Please ask for: Sian Eggington
Email: sian.eggington@terraquest.co.uk
Telephone: 0121 2341390
Our Ref: LU/82/21/HH
Your Ref:
Date: 17th May 2021

Application for Planning Permission for Works or Extension to a Dwelling

Development: Erect a new garage as a continuation of the north eastern projection.
Convert existing garage to a home office, utility and shower room.
Location: 101 Griffin Crescent Littlehampton BN17 7LH

Block PLAN

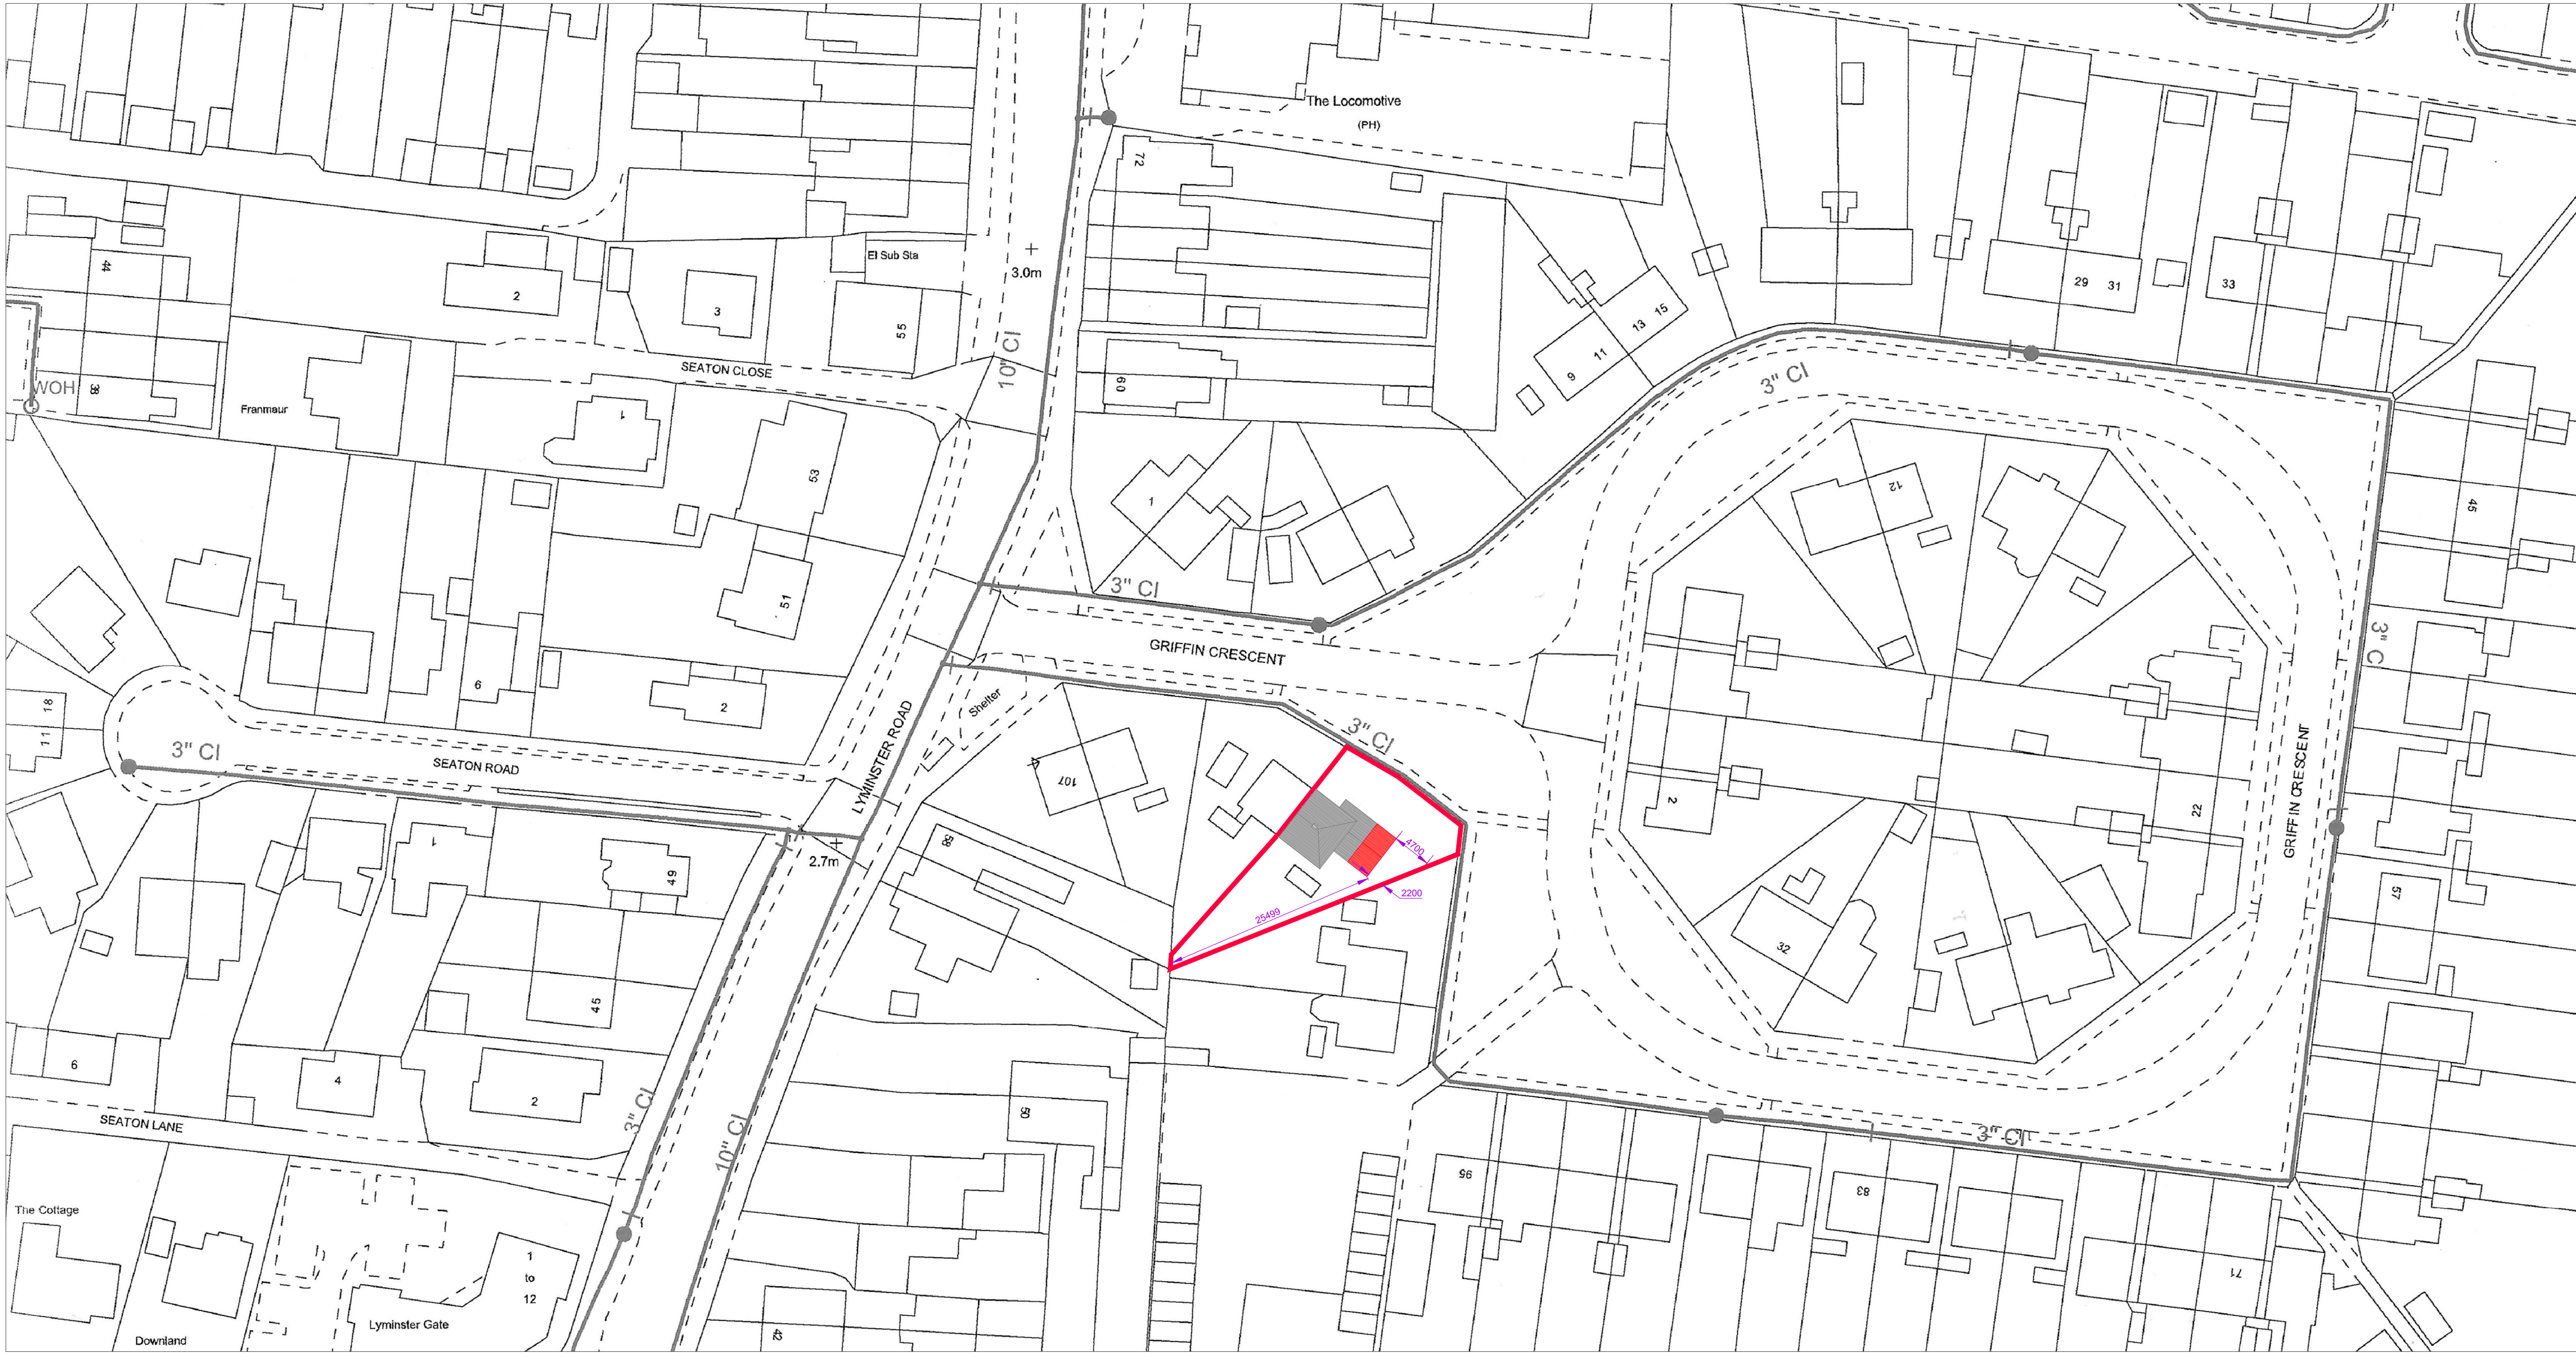
Block Plan

You are required to have dimensions from the proposed extension(s) to all site boundaries. Please amend.
